NOTICE OF EXHIBITION - SSD 6471 SYDNEY MODERN, AGNSW EXPANSION PROJECT

Thank you for the invitation to provide comments for the exhibition of the Sydney Modern, AGNSW Expansion Project (SSD 6471).

Tim Smith OAM
Director, Heritage Operations
Heritage Division
Office of Environment & Heritage
As Delegate of the Heritage Council of NSW
15 December 2017

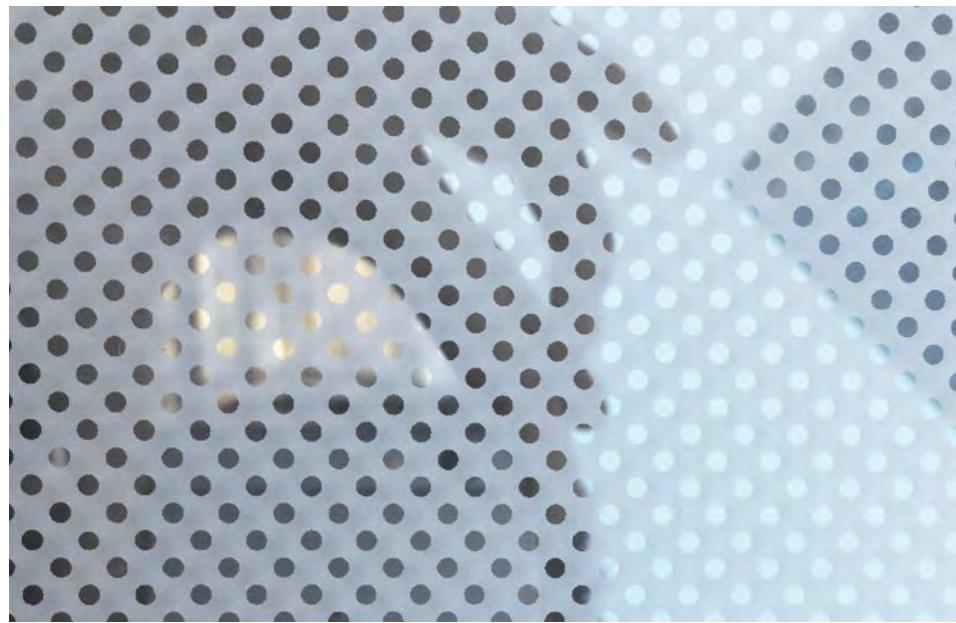
Issue	Heritage Council of NSW comment	Potential heritage impact	Recommendation - Amendment to proposal or condition of approval
Proposed Entry Plaza roof.	<p>At its meeting on 4 May 2016, the Heritage Council advised that the proposed shade structure has a potential to compete with the historic Art Gallery building.</p> <p>At its meeting 4 October 2017, The Approvals Committee felt that the entrance canopy is still massive and wonders if it needs to be that large.</p>	<p>The proposed Entry Plaza roof will be highly conspicuous in views along historic Art Gallery Road and will compete with and reduce the historic dominance of the AGNSW's west elevation and its portico. Any adverse visual impact will be exacerbated by the height of the proposed roof, its proximity to Art Gallery Road and its approximately 40m length seen from Art Gallery Road.</p>	<p>Recommended</p> <p>Despite the fact that the proposed Entry Plaza roof will be lower than the AGNSW's main cornice, its visibility along Art Gallery Road should be substantially reduced so the new roof does not compete with the existing building and its portico, and is clearly subservient to the existing gallery and the 1902 portico. This may be achieved either:</p> <ul style="list-style-type: none"> • by setting the roof behind the Art Gallery façade; and • by increasing the separation between the proposed entry plaza roof and the Art Gallery. <p><i>Reason: So that the new roof is still a contemporary addition to the overall composition, functions as an open shaded public area and identifies the entry to the new galleries, but is much less conspicuous and does not visually compete with the significant existing gallery and its portico.</i></p>

1 North Elevation
Scale: 1 : 250

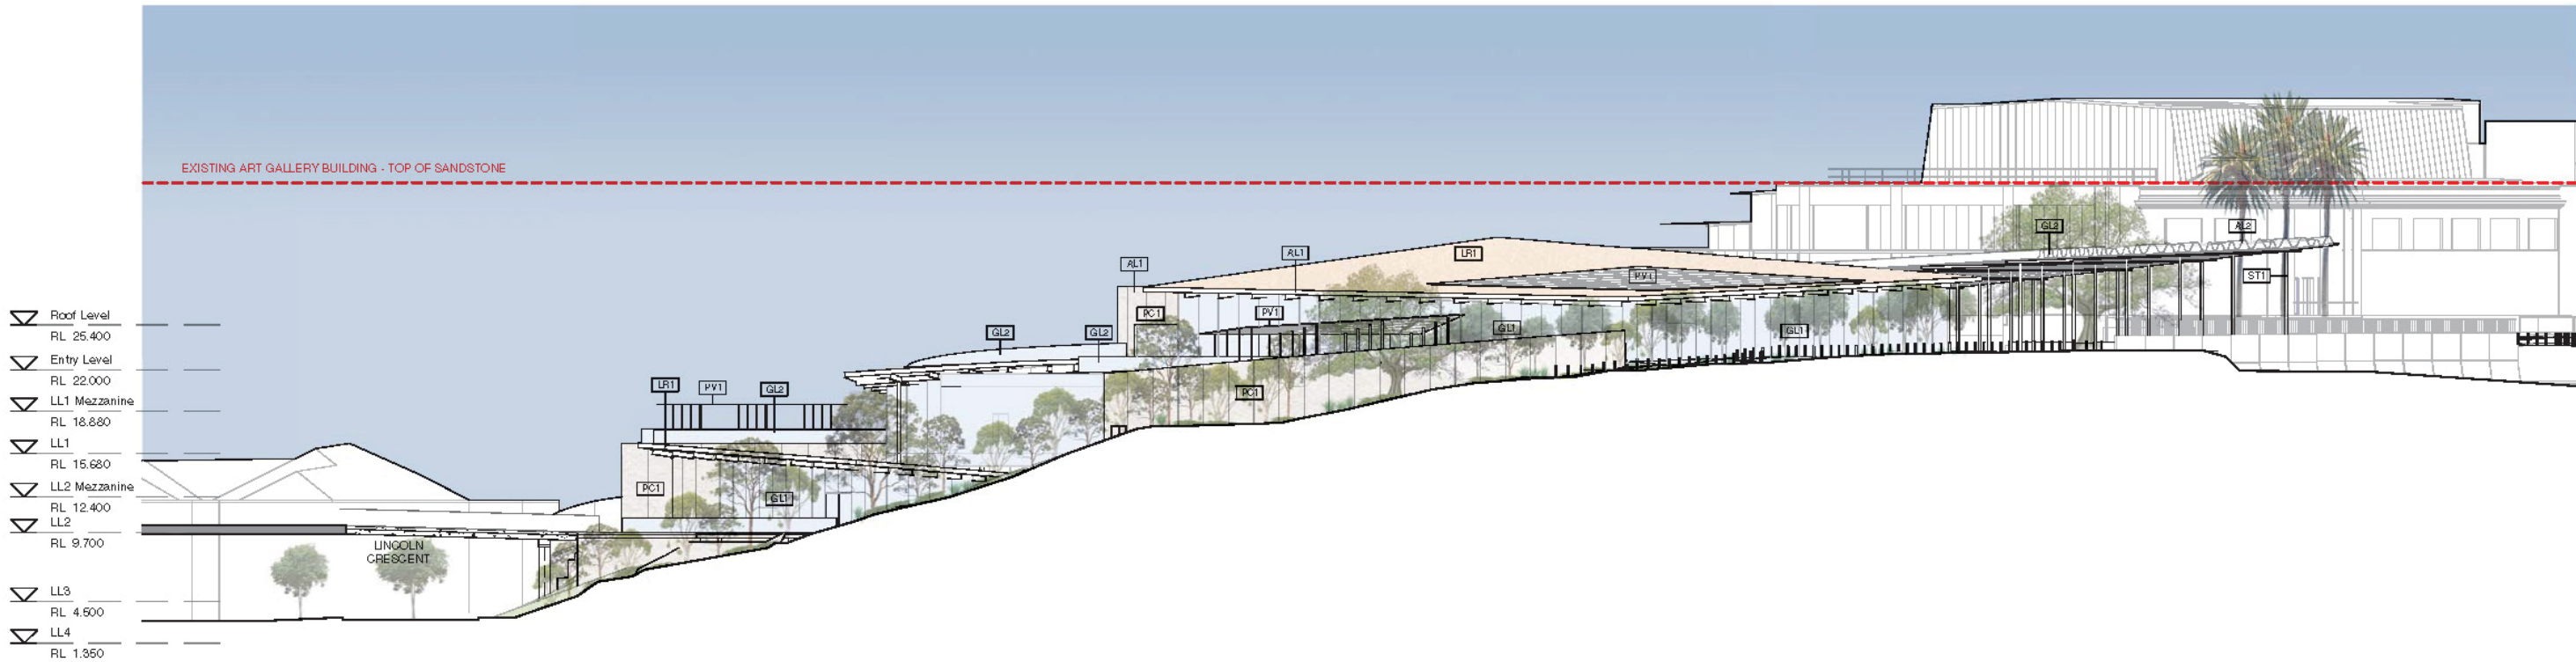
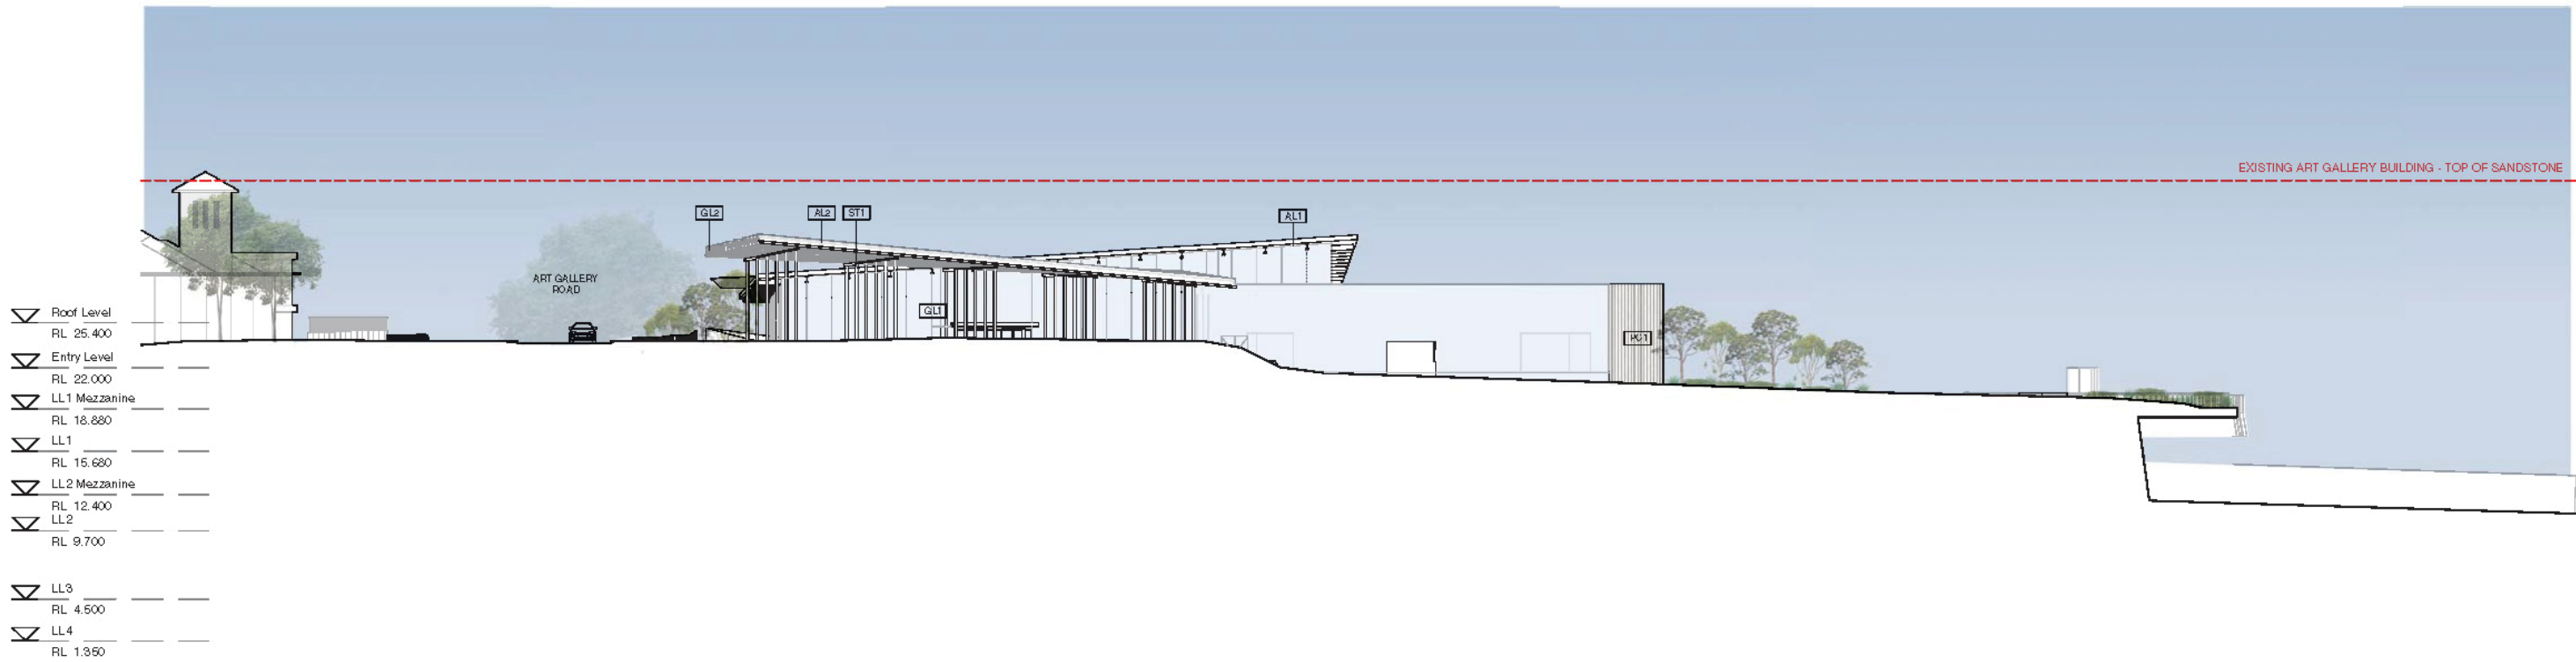
The character and setting of the eastern part of the Domain and significant views.	The character and setting of the eastern part of the Domain and any impact on significant views to and from the RBG&D were not presented in detail to the Heritage Council.	<p>The proposal will alter the character of the eastern part of the Domain. Significant views that would be markedly affected include:</p> <ul style="list-style-type: none"> • East from Woolloomooloo Gate • North and south along Art Gallery Road. <p>The proposed Entry Pavilion and Gallery 2 and the PV roof array will block the Woolloomooloo Gate view (Public Viewpoint 11, Visual Impact Assessment) and the Entry Pavilion and Plaza roof will block most of the view to the 1902 portico south along Art Gallery Road Public Viewpoint 12). The Entry Pavilion and Plaza roof will be conspicuous in the view north along the Art Gallery Road, beyond the AGNSW.</p>	<p>Recommended:</p> <p>High reflective surfaces, large areas of unshaded glass and bright white finishes should be avoided. External colours should be subdued and take inspiration from the colours of the locality, that is Sydney sandstone.</p> <p><i>Reason: To reduce the impact on the Domain's character, setting and significant views. So that the appearance of this intricately composed building is subdued and sits comfortably into the landscape</i></p>

Issue	Heritage Council of NSW comment	Potential heritage impact	Recommendation - Amendment to proposal or condition of approval
		The application does not confirm the proposed external solid walling, except as polished pre-cast units and there are no proposed colours. It is recommended that the proposed building should be much less conspicuous in all views and its external colours and materials should be subdued and take inspiration from its location on Sydney sandstone.	
Damage due to vibration during construction	Damage due to vibration during construction was not presented in detail to the Heritage Council.	<p>The Geotechnical Report Oct 17 advises that the ground adjacent to the development may experience movement due to stress changes from excavation, footings and construction. This may affect the existing building.</p> <p>Vibration as a risk to the existing building is not addressed in the draft Construction Management Plan which focuses on vibration as noise nuisance.</p>	<p>Recommended;</p> <p>A heritage specific dilapidation survey and report for significant elements, materials and finishes in the existing gallery building and site (including the forecourt sculptures) is to be prepared prior to commencement of the works. The construction management plan for the development is to identify and include these significant elements, materials and finishes so that they are protected and not damaged during the work.</p> <p>The finalised construction management plan for the development should be submitted to satisfaction of the Heritage Council of NSW or its delegate for review prior to the issue of the construction certificate.</p> <p><i>Reason: To protect significant elements, materials and finishes during the work.</i></p>

Fig 8.0A – Proposed location of intake and discharge points

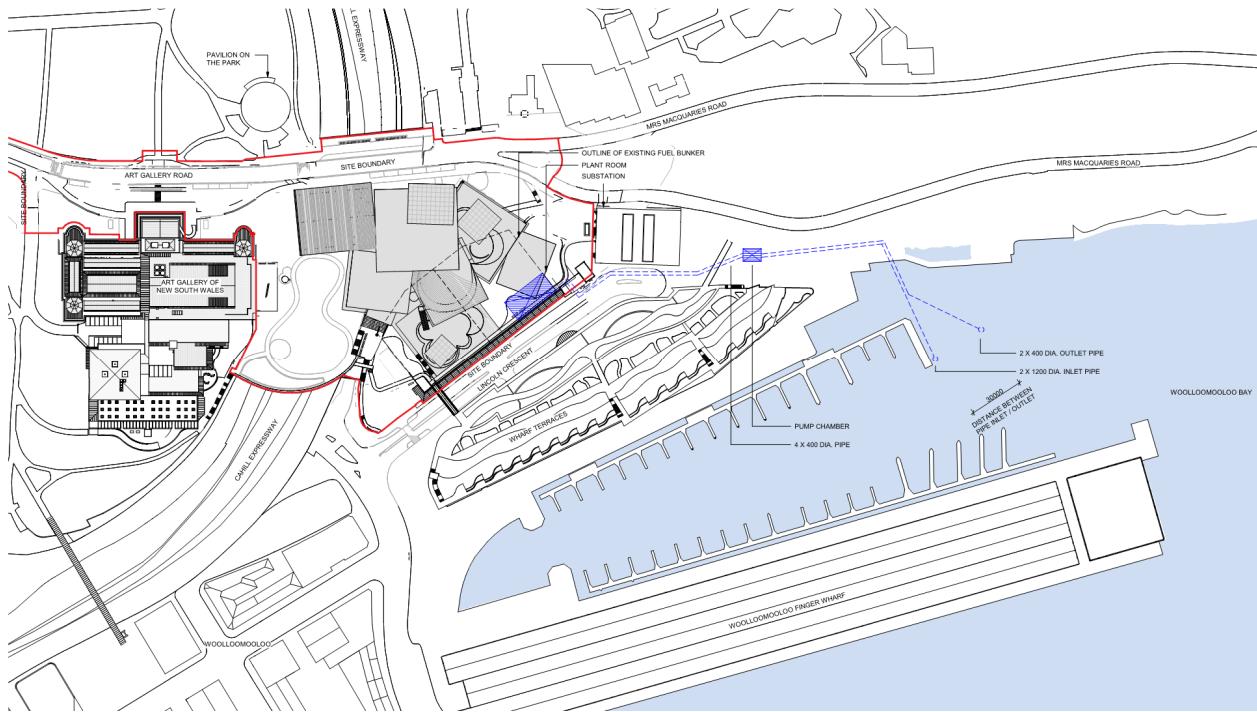
The proposal involves a new ancillary seawater heat exchange system consisting of outlet and inlet pipes laid through the sea wall and up to 60m into Wolloomooloo Bay. The proposal has the potential to substantially impact maritime heritage sites both above and below water and under the seabed. As with historical archaeology, the maritime archaeological potential in Wolloomooloo Bay and its foreshore as well as the extent of any disturbance was not clarified in the proponent's presentations to the Heritage Council on 4 May 2016 and the Approvals Committee on 4 October 2017.

The information submitted with the application does not adequately deal with maritime archaeology. There is no search of the NSW Maritime Heritage databases listed in the documents and the site surveys only involved visual surveys from the foreshores and did not include any diver inspections. This is considered to be unsatisfactory. The impact could be substantial as the large inlet and outlet pipes are proposed to run approximately 60m out into the bay. With this, it is recommended that a detailed Maritime Archaeological Assessment, and Research Design and Excavation Methodology be prepared as soon as possible and before the assessment and determination of SSD 6471.

The maritime archaeological assessment should be prepared by a suitably qualified and experienced maritime archaeologist. The assessment should identify the archaeological potential and significance of maritime heritage sites including shipwrecks, maritime infrastructure, archaeological items and/or relics (both above and below water) that may be impacted by the proposal. The assessment should also include procedures and management strategies for the unexpected discovery of heritage items and/or relics. Underwater surveys may also need to be undertaken and may require remote sensing and/or diver based investigations. The Maritime Archaeological Assessment should be submitted to the satisfaction of the Heritage Council of NSW or its delegate for review prior to the assessment and determination of SSD 6471.
